Consultation Response from KC, Highways Development Management
2023/92359 Land at, Station Road, Meltham, Holmfirth, HD9 4NL
Discharge condition 7 (improvement works to Station Road), 10 (Validation Report) on previous permission 2022/93376 for erection of 7 detached dwellings including associated car parking and turning head
Date Responded: 24/10/23 Responding Officer: CNB Responding Ref: K3-15/11

This application is for the discharge of conditions 7 (improvement works to Station Road) and 10 (validation report) of previous permission 22/93376 for the erection of 7 detached dwellings including associated car parking and turning head.

This response deals with condition 7 (improvement works to Station Road) only.

Project	Station Road Meltham		
Client	Brierstone Ltd.		
Drawing	Hard Paving Specifications		
Number	1309-902	Rev	A
Scale	1:200@A1	Drawn	SJG
		Checked	
		Date	Jul 2022

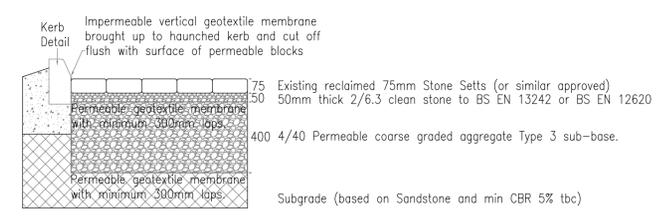
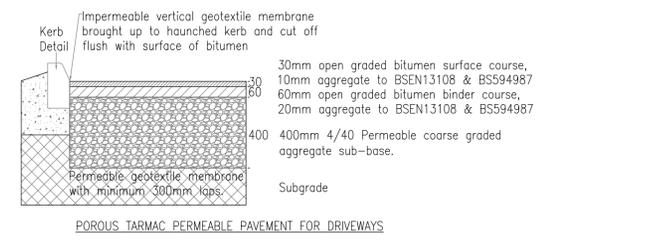
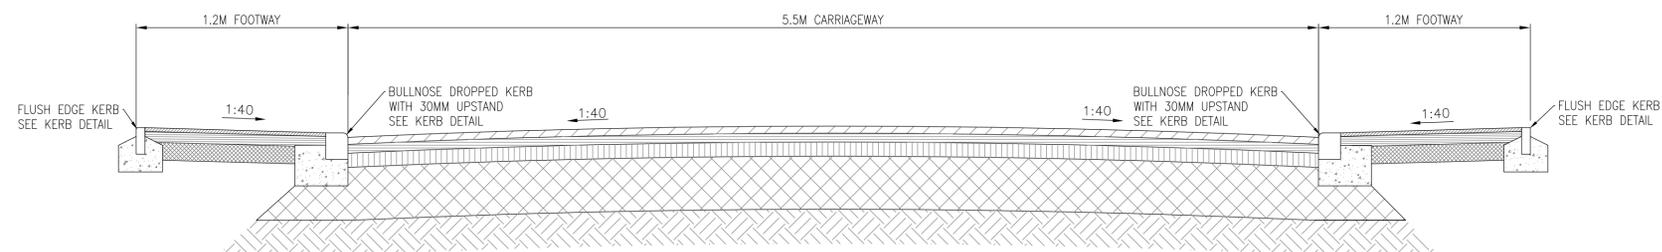
This application was accompanied by a technical drawing No 1309-902 Rev A showing the construction details for the turning head, access road (Station Road) and the driveways.

The details provided show that the construction will be carried out to adoptable standards (although it is noted that the highway is unadopted and unlikely to be offered for adoption).

These details are suitable for the discharge of condition 7 of previous permission 22/93376.
eltham
